Single storey double garage
25 Elm Grove Barnham

I regret that I am unable to accept your documents as a formal application until the following matters have been resolved :-

SITE PLANS

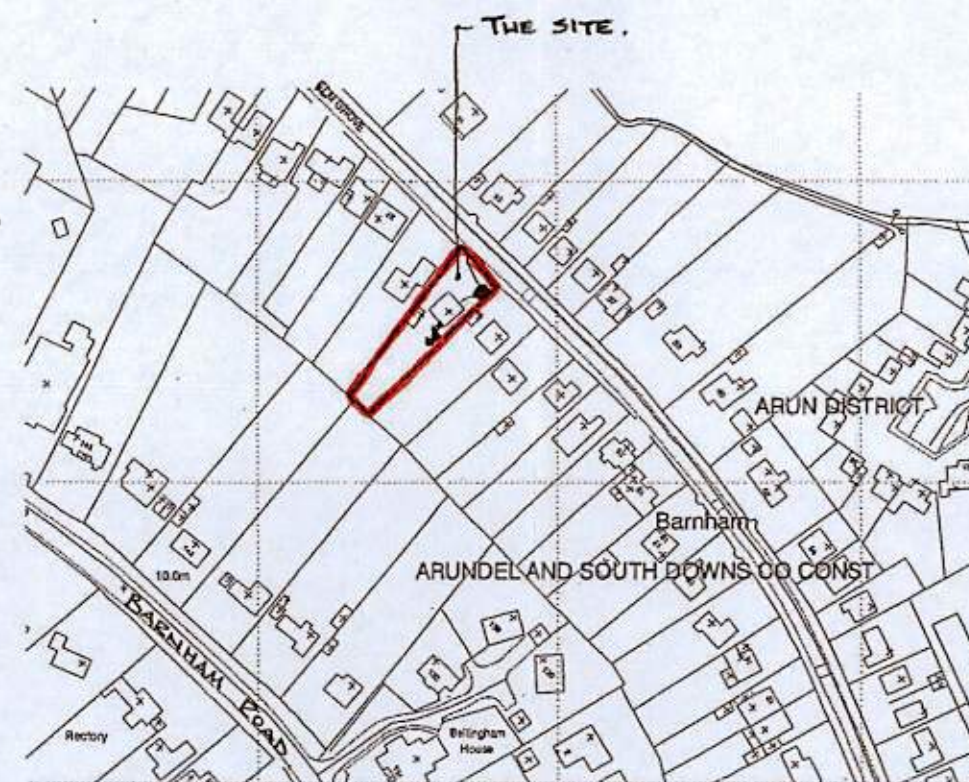
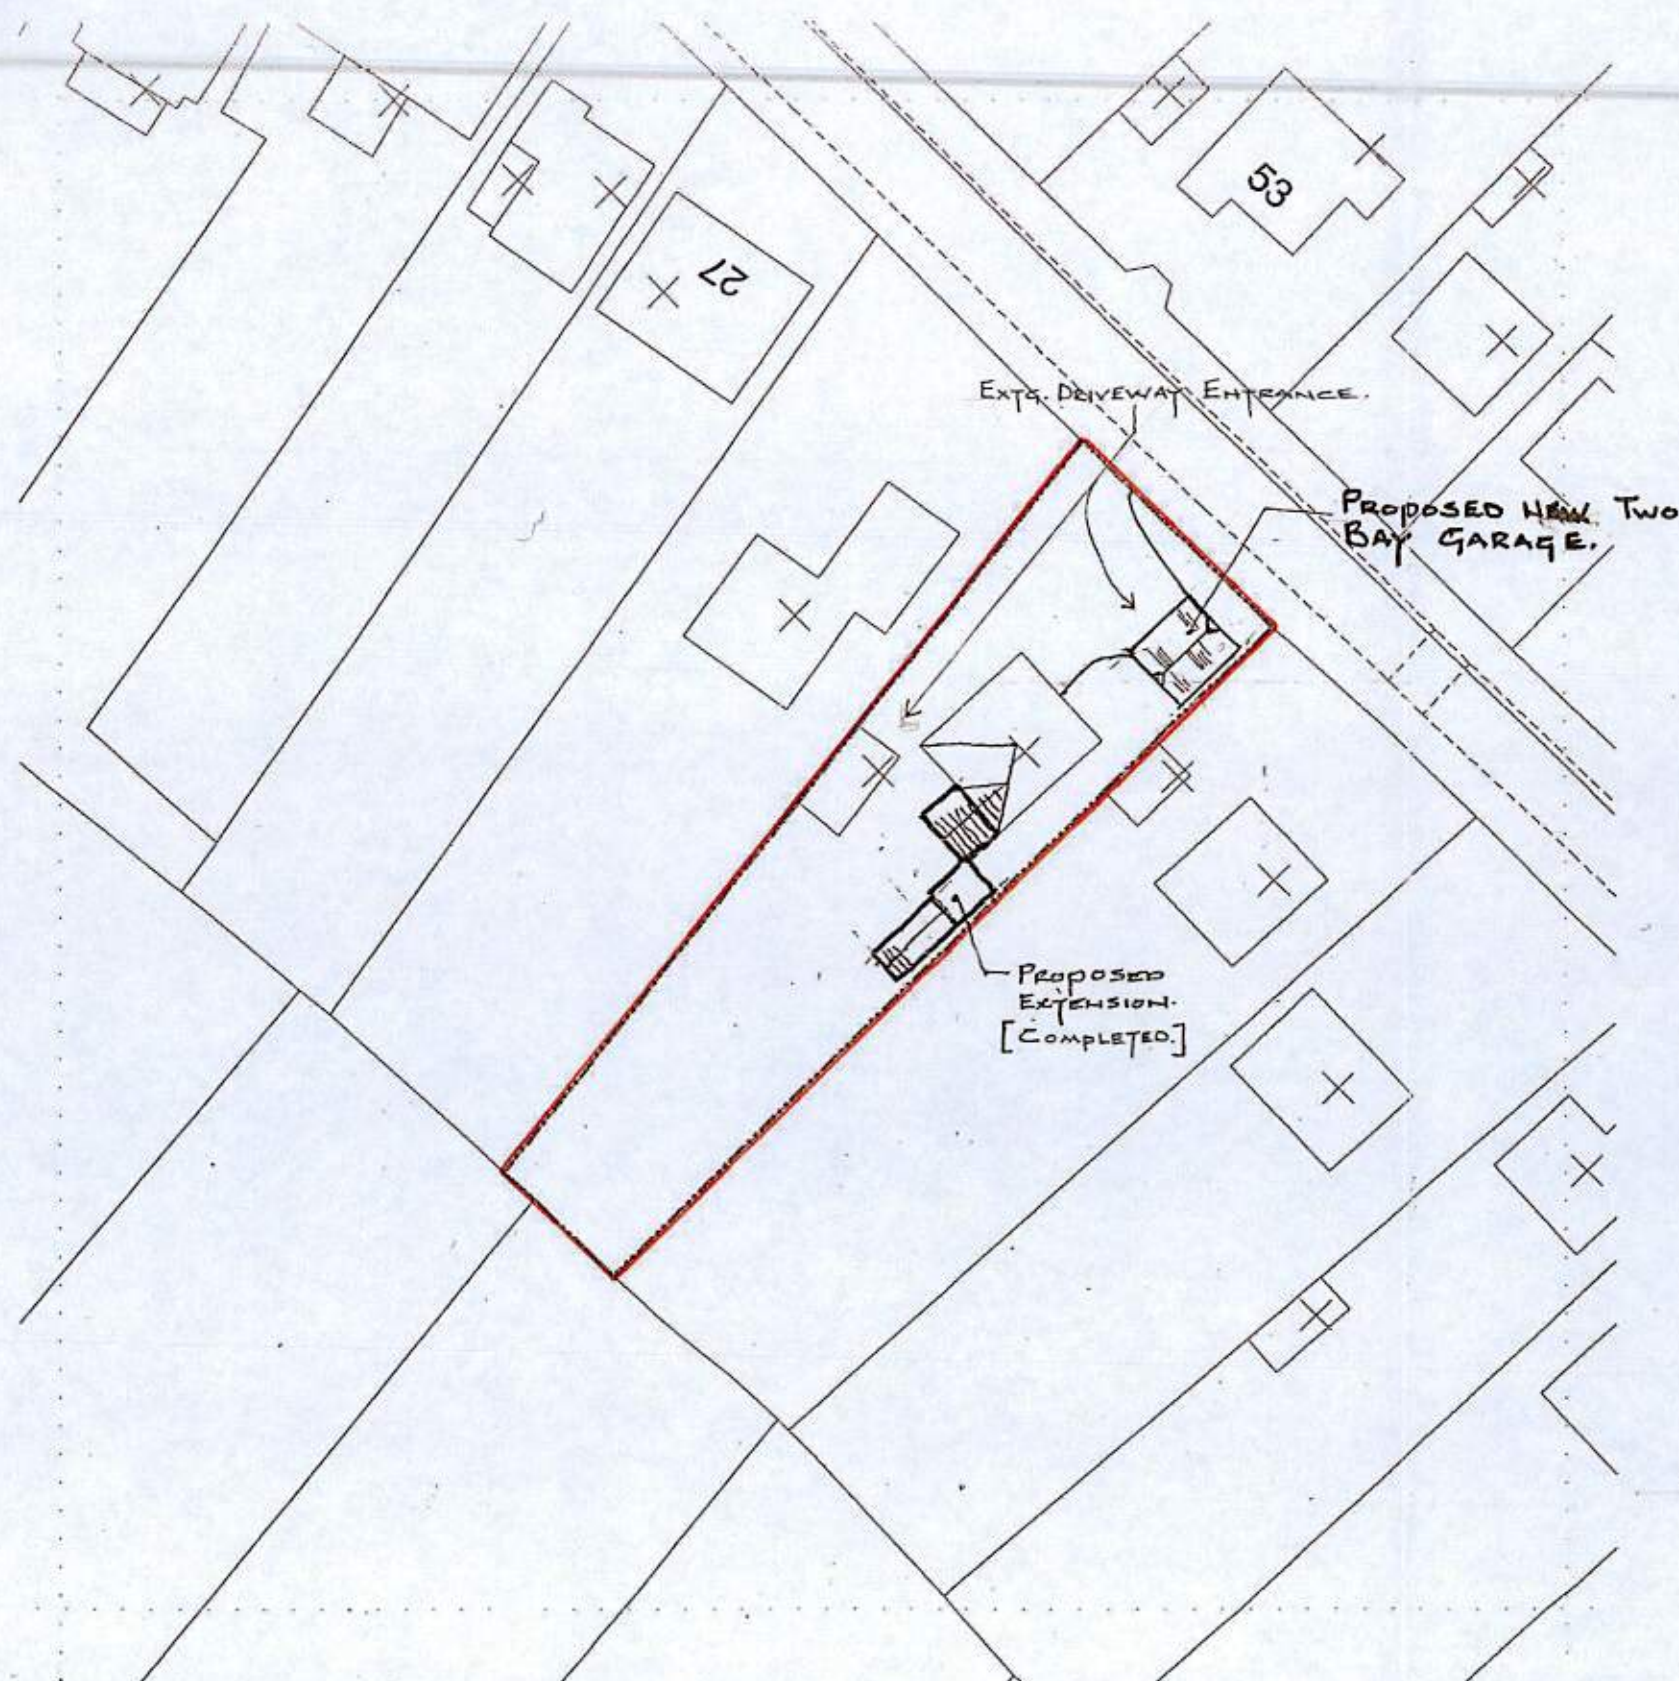
I require 1 electronic or 3 paper copies of a location plan in accordance with the guidance notes available on our website detailed below (click on National List). Please provide another named road.
